# CITY OF ALBUQUERQUE

**Re: Sawmill market**  
**1909 Bellamah Ave. NW Albuquerque NM**  
**Traffic Circulation Layout**  
Engineer's/Architect's Stamp 07-23-18 (J13-D017A)

Based upon the information provided in your submittal received 07-23-18, the above referenced plan cannot be approved for Building Permit until the following comments are addressed:

A1 SITE PLAN
1" = 20'-0"

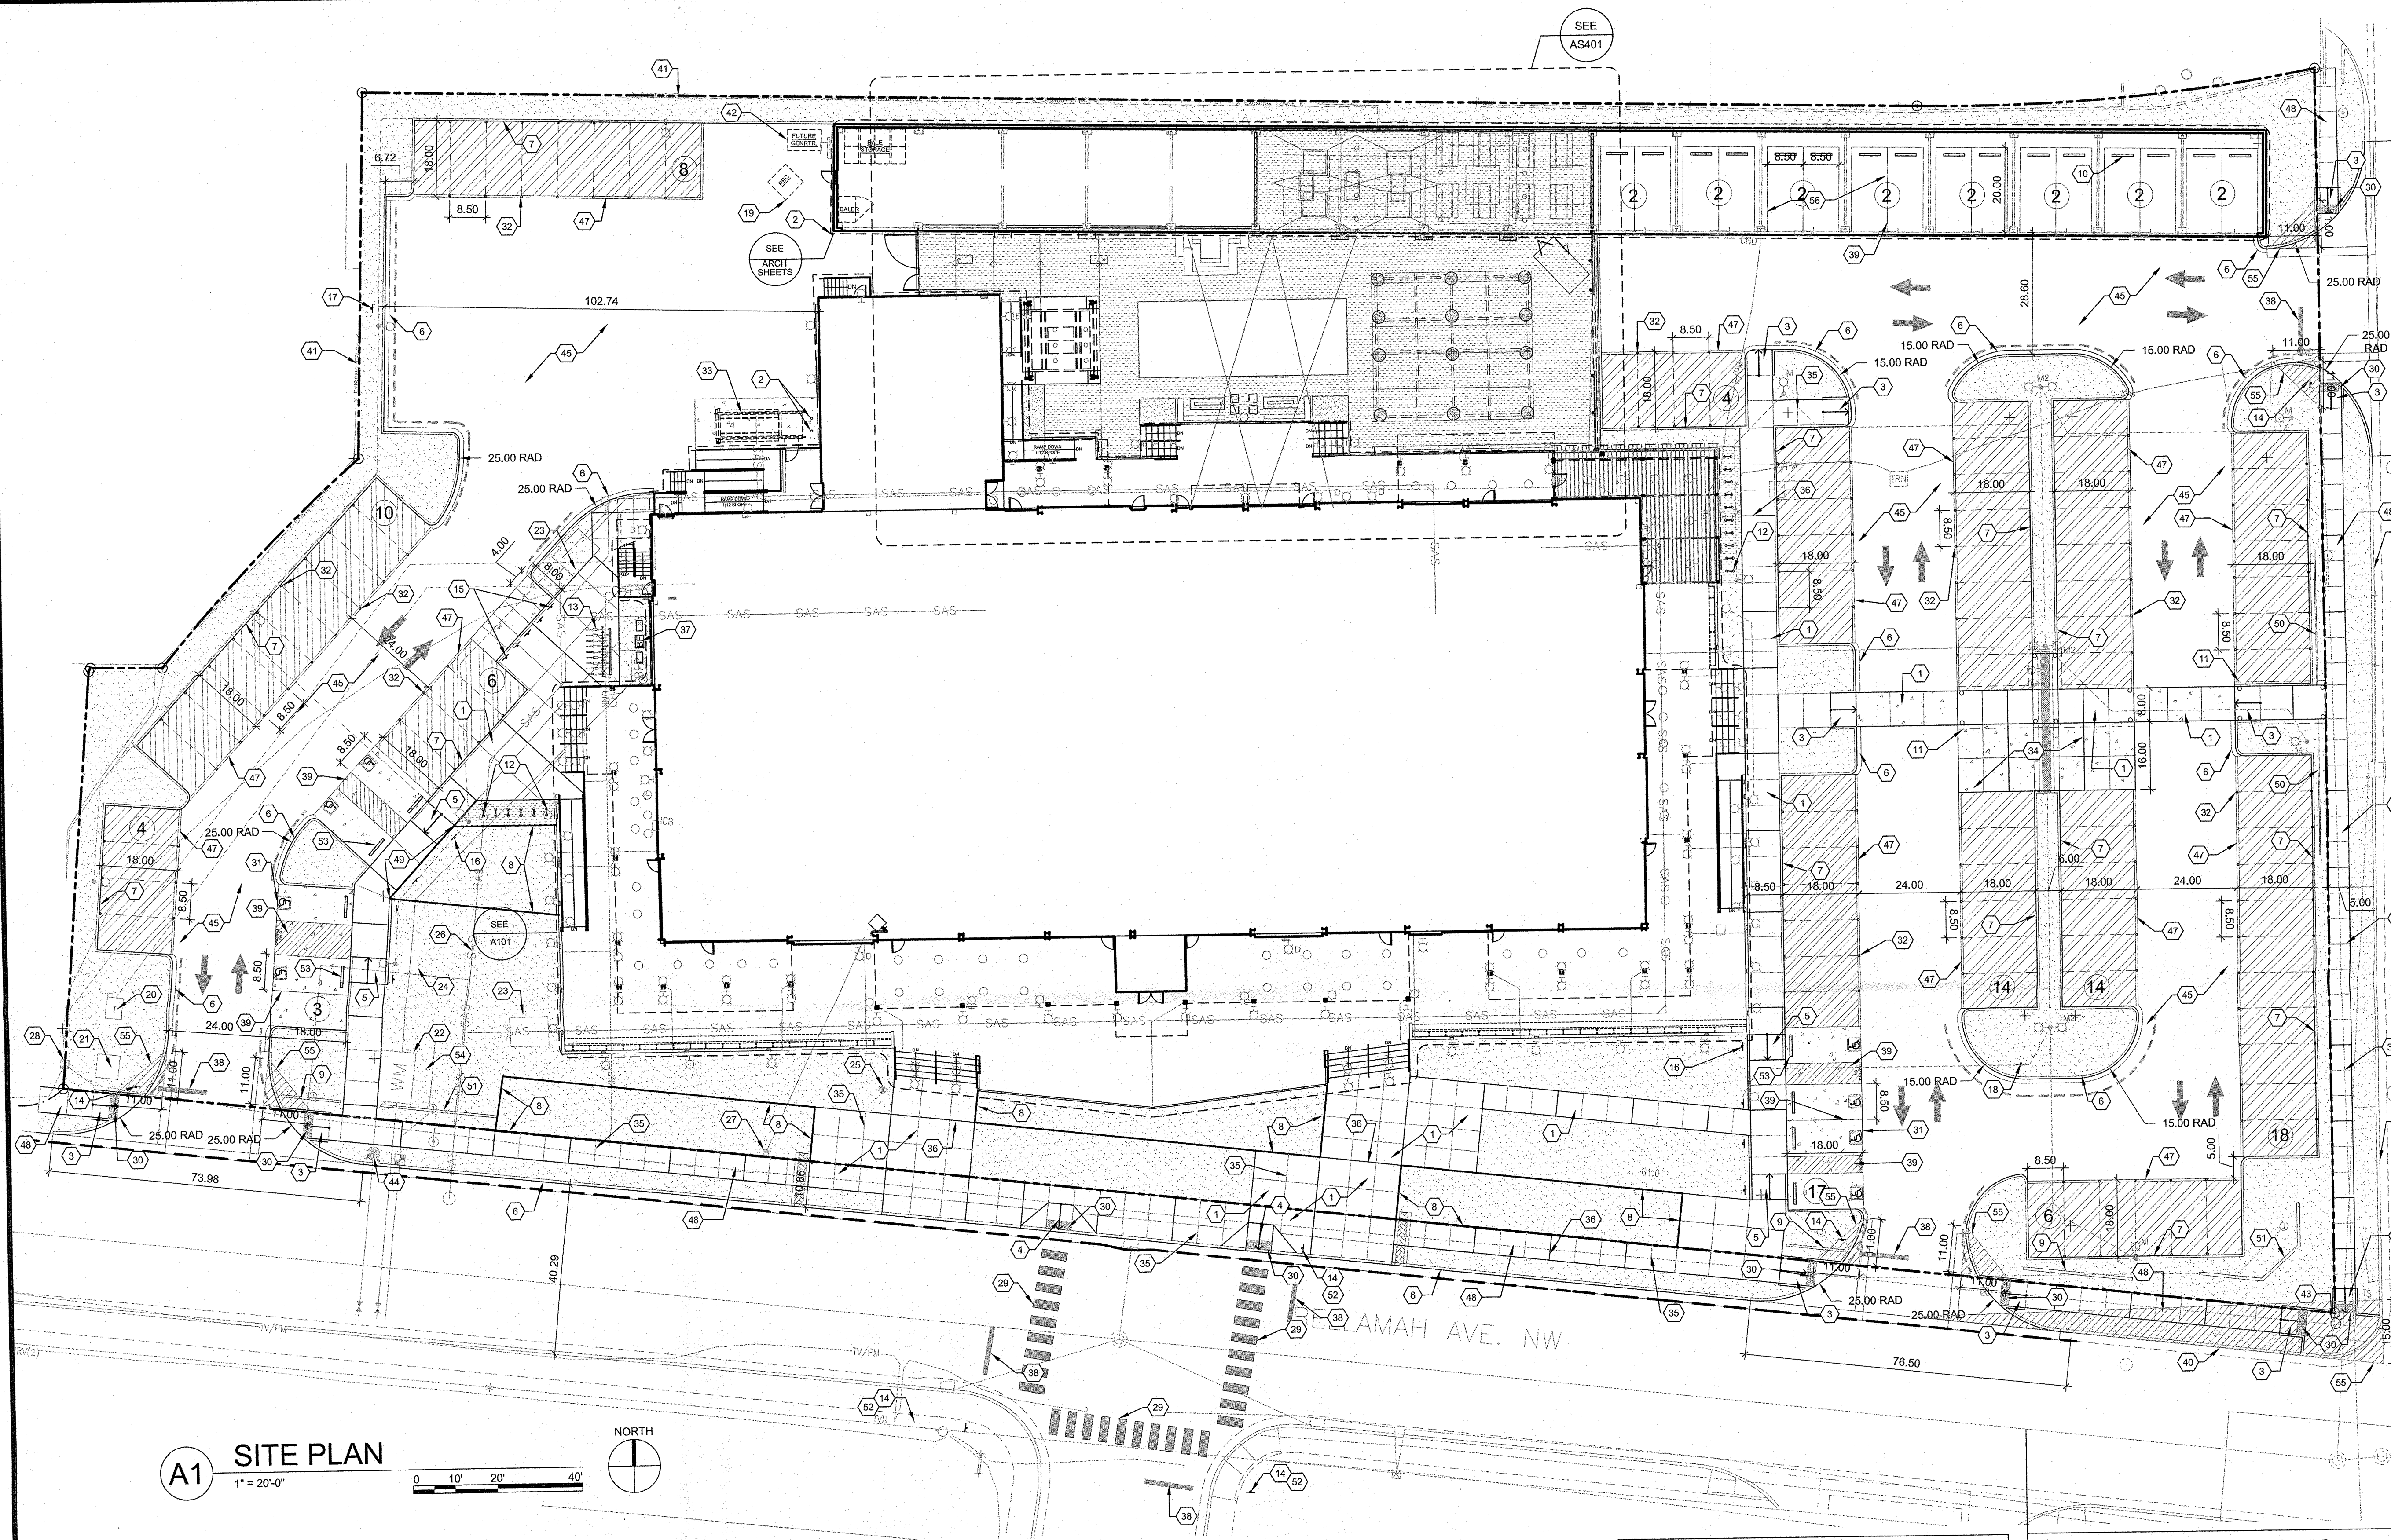
1. Please list the width and length for all existing and proposed parking spaces. Some dimensions are not shown.
2. The number of provided parking spaces doesn't match the existing parking spaces.

3. The dimension of the access is unclear.
4. A 5 ft. keyway is required for dead-end parking aisles.
5. Show the clear sight triangle and add the following note to the plan: "Landscaping and signage will not interfere with clear sight requirements. Therefore, signs, walls, trees, and shrubbery between 3 and 8 feet tall (as measured from the gutter pan) will not be acceptable in the clear sight triangle."

6. Provide additional shared parking information. It's not clear where all the parking is located and how it will be accessed by pedestrians.
7. Provide all the detailed sheets such as AS501.

8. Provide note regarding parking on the north end of the site. It's not clear what type of parking space is being proposed.
